Your Reference
SSD-83258708

Florida Street, Sylvania, Affordable Housing — Response to Submission

Reference is made to the proposed development at 29 Florida Street, Sylvania, which is currently progressing under SSD-83258708 and is at the *Response to Submissions* phase.

This correspondence is to be read in conjunction with the Flood Impact and Risk Assessment Report, Revision D, dated 02 April 2026, which has been updated accordingly to reflect the outcomes of the review process.

Map 14 - 1% AEP - Design Scenario - Flood Hazard

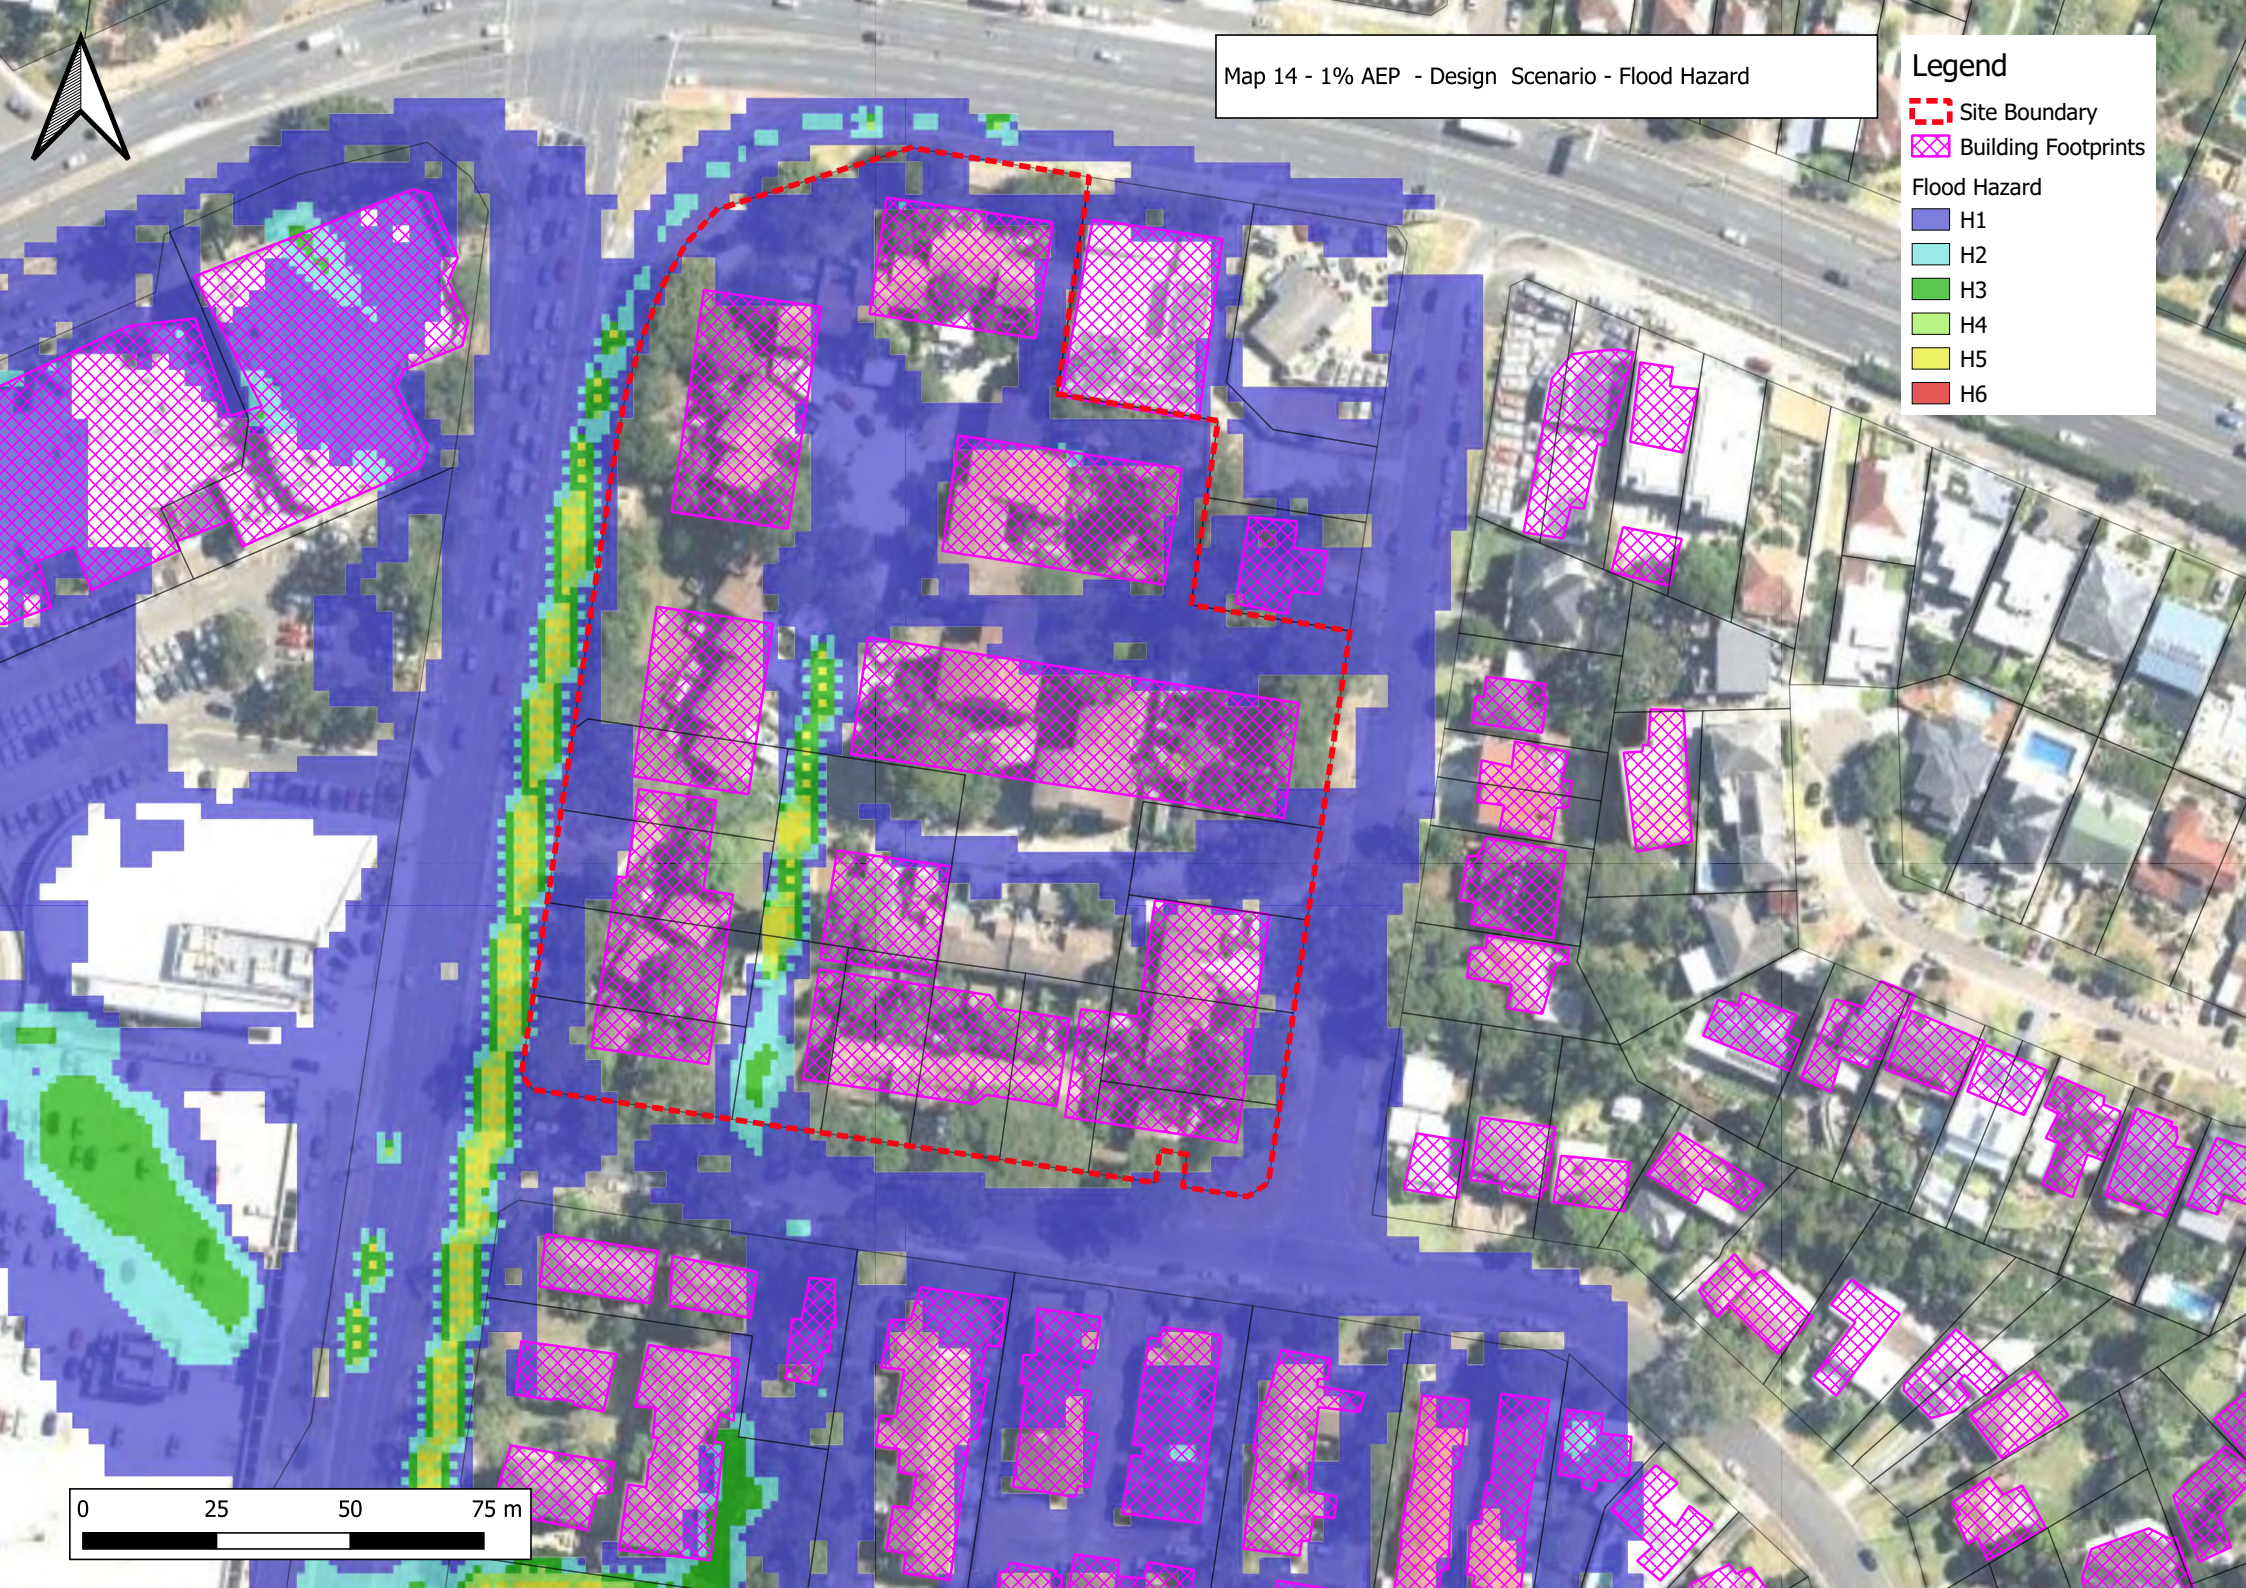
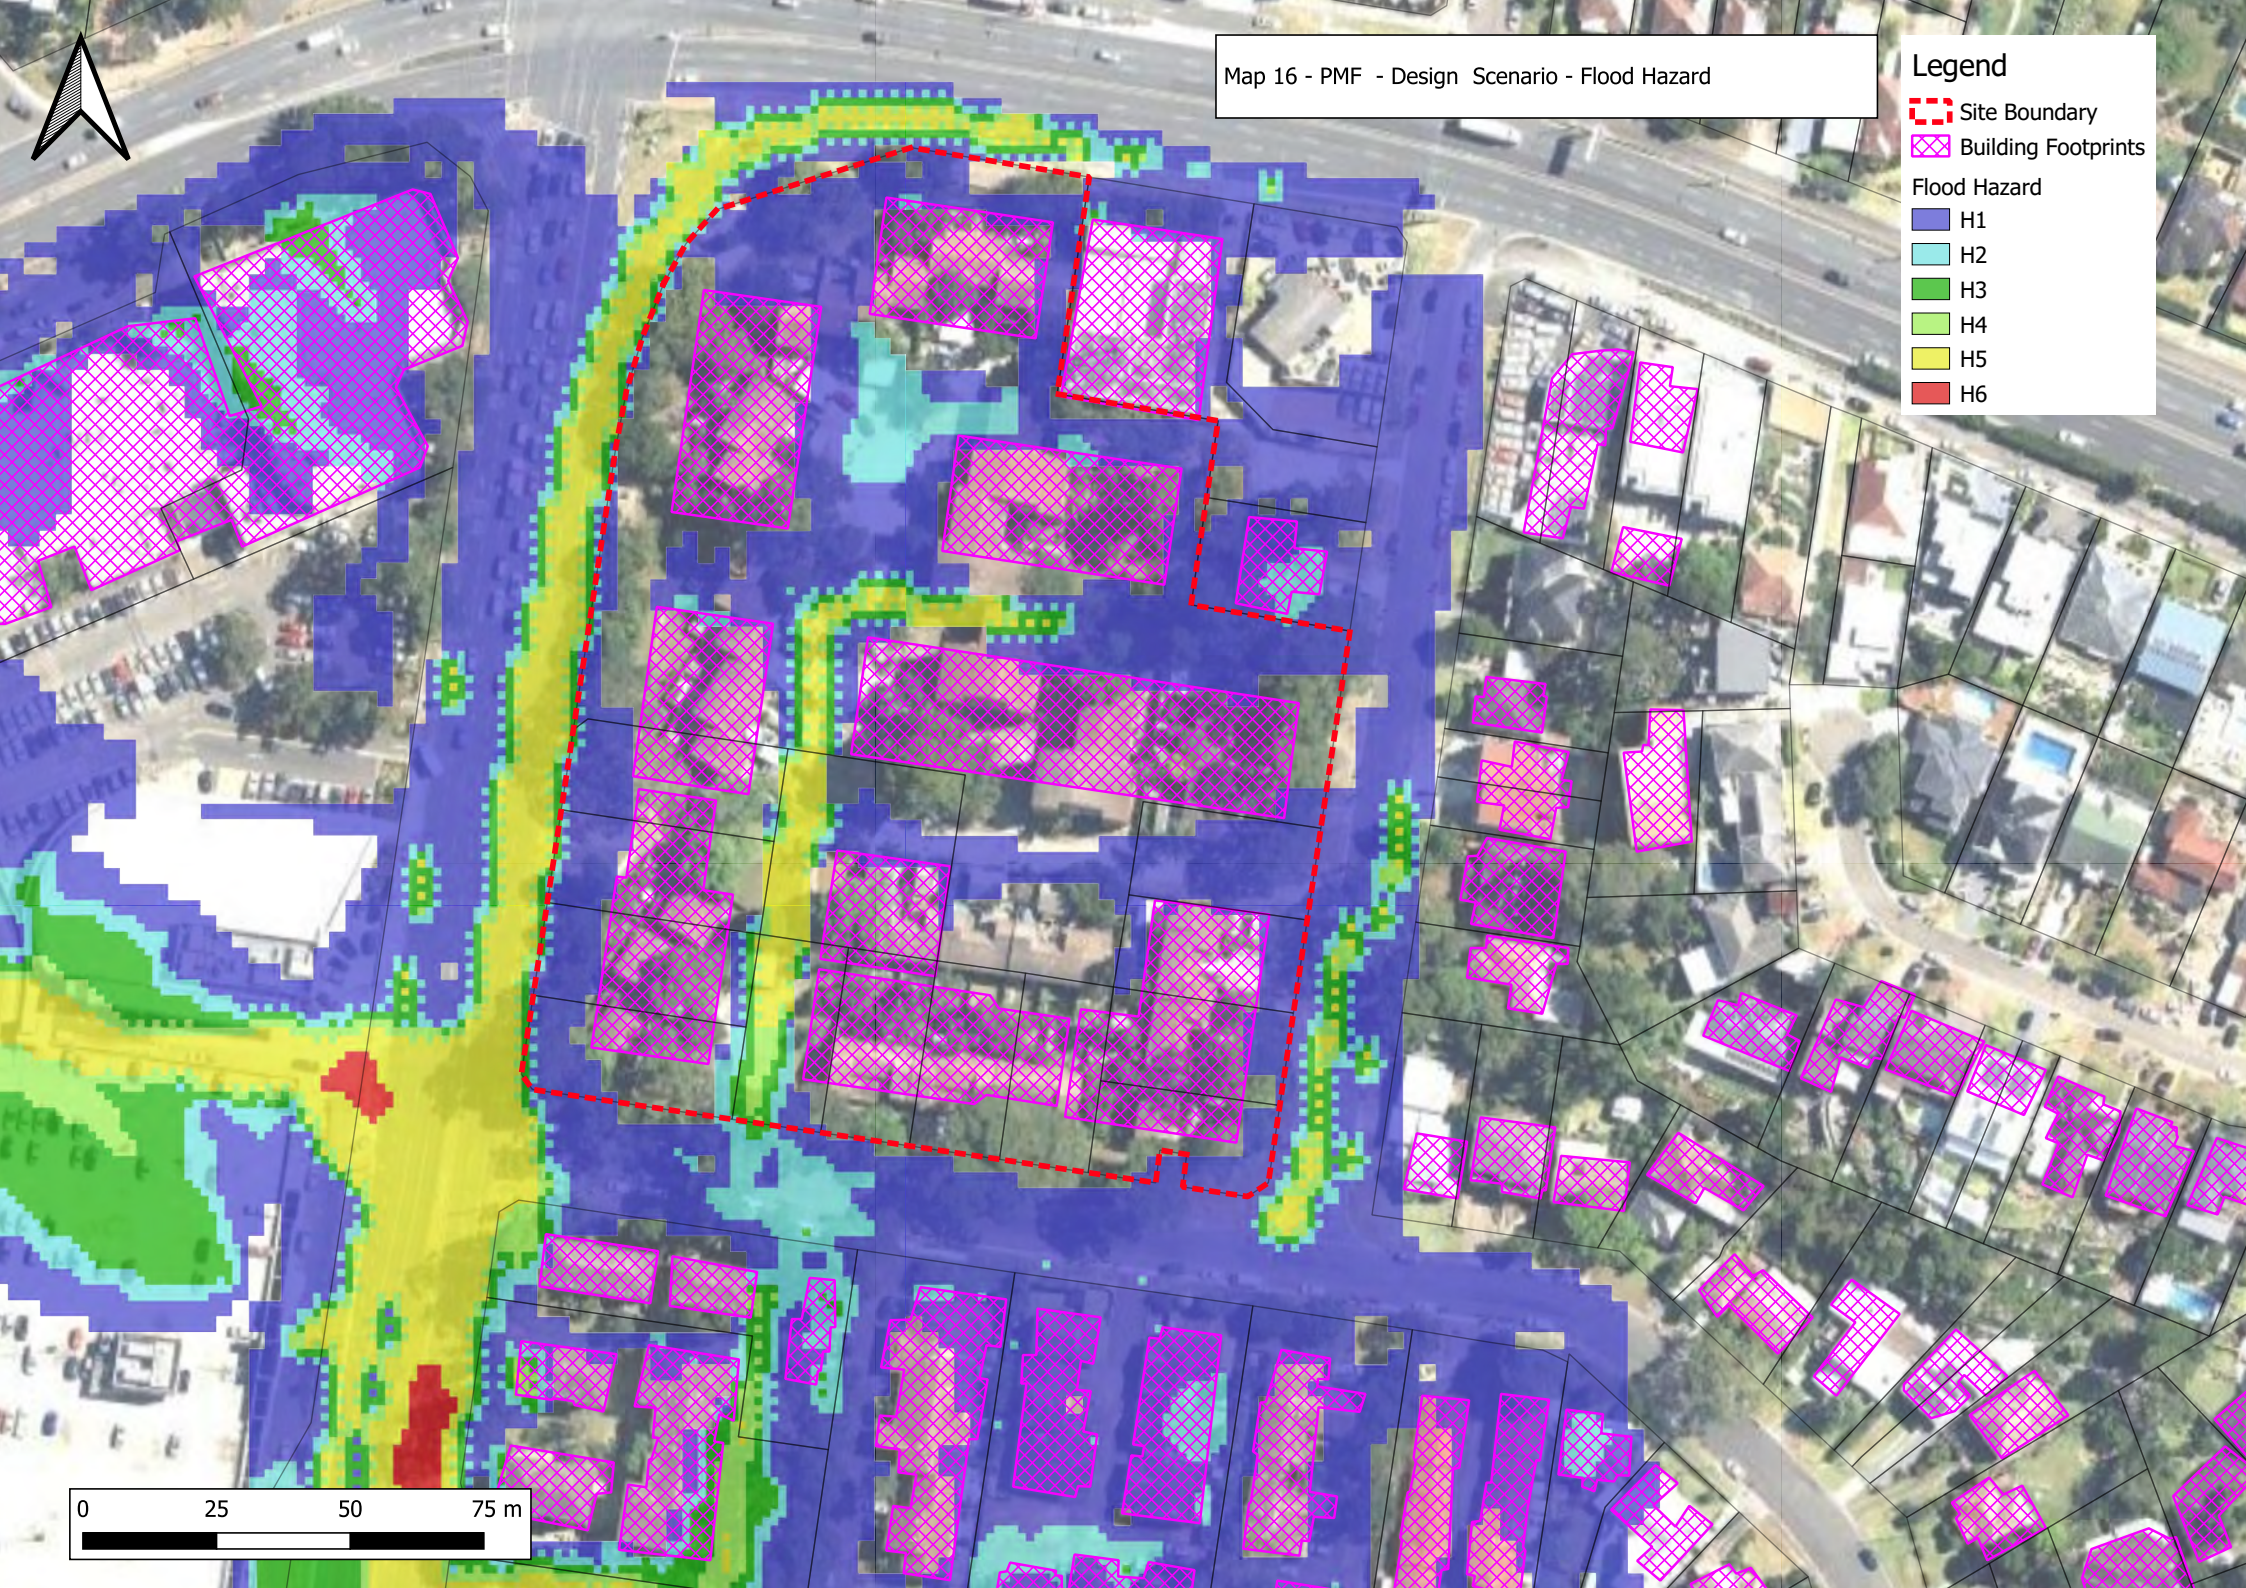
1.2	Onsite flood risk management The FIRA demonstrates that offsite impacts have been limited by the design of the onsite storage and internal roads within the site however this has resulted in high hazard flooding in an internal courtyard and on the internal roads. The FIRA has not shown how the residents of the development and their visitors would be protected from the risks posed by the high hazard flooding on the internal roads and the flood storage in the courtyard. Recommended action: The FIRA to demonstrate how risk to residents will be appropriately managed or amend the design to mitigate those risks.	Updates to the FIRA Flood Emergency Management section 6.3, to address how people are to be separated from on-site hazards. Note that detailed landscape design is yet to be complete (detailed design stage), flood emergency response is designed for people to not be exposed to on-site hazard.

1.3	Evacuation strategy - The site currently has good low hazard access from Florida Street however the proposed on site mitigation measures create a high hazard on internal roads which isolates part of the site from the evacuation route. - The FIRA indicates that the primary evacuation strategy is evacuation of the site prior to a flood event under the direction of the NSW State Emergency Services (SES). The site is in a flash flood area without flood warning. It is considered unlikely that the SES will direct residents to evacuate. - Shelter in place (SIP) is considered by CPHR to be the preferred primary evacuation strategy. This requires the FIRA to address the considerations included in the Shelter in place guideline for flash flooding (Department of Planning, Housing and Infrastructure, 2024). - The internal roadways isolate part of the site from evacuation or assistance due to H3 to H5 hazards which occur for storms as frequent as the 5% AEP event. The hazards on the internal roadways do not comply with the Sutherland Shire Development Control Plan 2015 (DCP)	Concerns noted relating to the speed of storm onset->flood onset. SIP is a valid strategy and localised overland flows are managed via grading of the precinct to allow people to achieve safe refuge. Considerations of the SIP guideline to be added into FIRA Section 6.3 With the SIP as primary response strategy there is no need for vehicles to exit the development during flooding. The worst-case flooding depicted in these FIRA maps relate to very short-lived flooding conditions, so concerns relating to access must be considered in light of this.

2.1	The proposed design increases flood hazard within the site posing a risk to life to site users. By including the proposed mitigation measure of “the channelisation of overland flows within the Site to the internal roadway”⁴ the hazard within the site itself is increased in all flood events from the 20% AEP flood,⁵ with flooding within the site during the PMF increasing from H2 to H5.6	Hazard footprints are significantly reduced from existing conditions through provision of new structures raised above PMF levels of the adjacent flow paths. The peak flood hazards mentioned here are located in the centre of the new design road – a deliberate flow path which draws water away from the structures. SIP provisions made for people to achieve safety.
